**PLANNING ACT 2008 (AS AMENDED) – SECTION 55:  
APPLICATION BY HIGHWAYS ENGLAND FOR AN ORDER GRANTING DEVELOPMENT  
CONSENT FOR THE M42 JUNCTION 6 IMPROVEMENT SCHEME**

Following the Issue Specific Hearing on 21 August, Birmingham Airport Limited write to respond to Requirements R1, R3, R4, R5 and R8 with a view to reaching agreement and inclusion within the next draft of the DCO.

# M42 Junction 6 Development Consent Order

## **8.20(b) Statement of Common Ground with Birmingham Airport Ltd**

Figure 1: Main Site Compound - Consideration of Alternatives

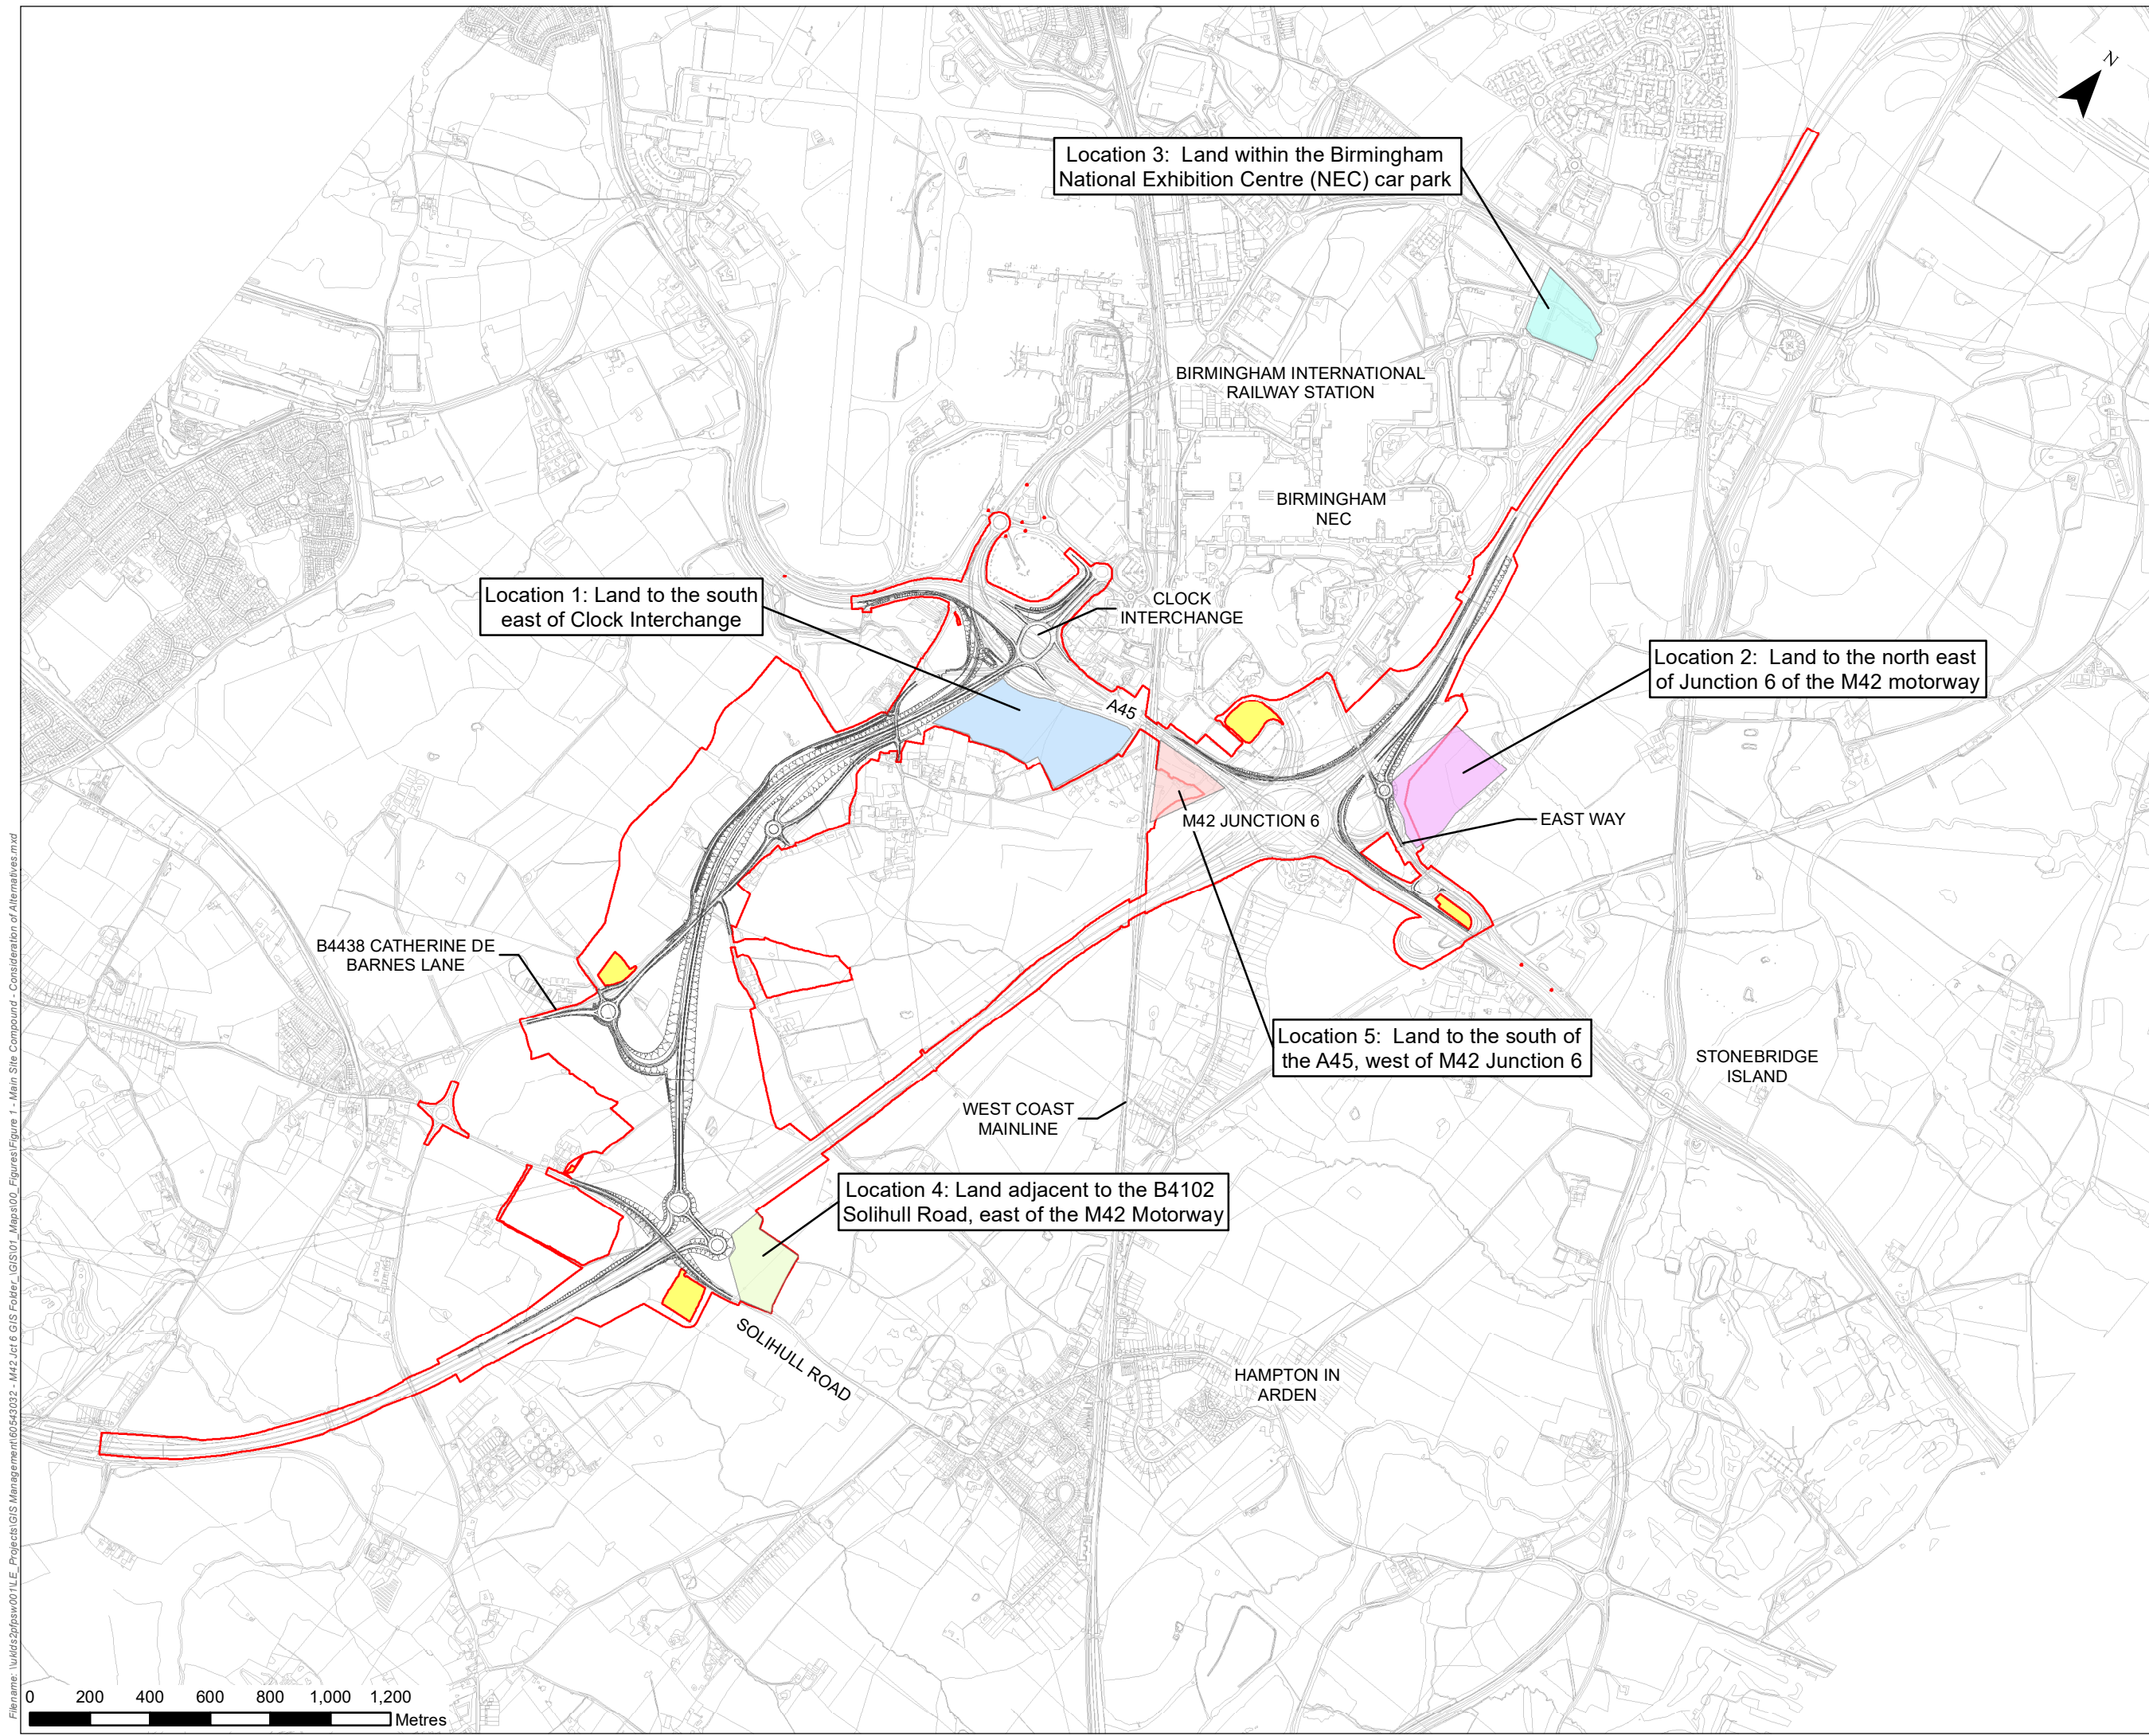
In terms of the construction compound, we have reviewed the plans from an Obstacle Limitation Surface (OLS) perspective and request that steps are taken to ensure that there is no conflict between the compound features and the Airport OLS overlying the preferred site.

The western part of the site lies underneath the Runway 33 Transitional Surface and the eastern portion under the Inner Horizontal Surface. Detailed planning of the site compound should therefore be undertaken to gain the Airport's approval from an OLS safeguarding perspective.

In addition to the above, there should be no use of any radio equipment within the compound area, without prior agreement with Birmingham Airport Limited.

Whilst the Airport have no 'in principle' objection to any of the proposed compound locations, we do ask that we are consulted on the details of how the construction compound are managed to ensure there is no adverse impact on safeguarding. This would be done by inserting an additional clause into Requirement 4, which would read as follows:
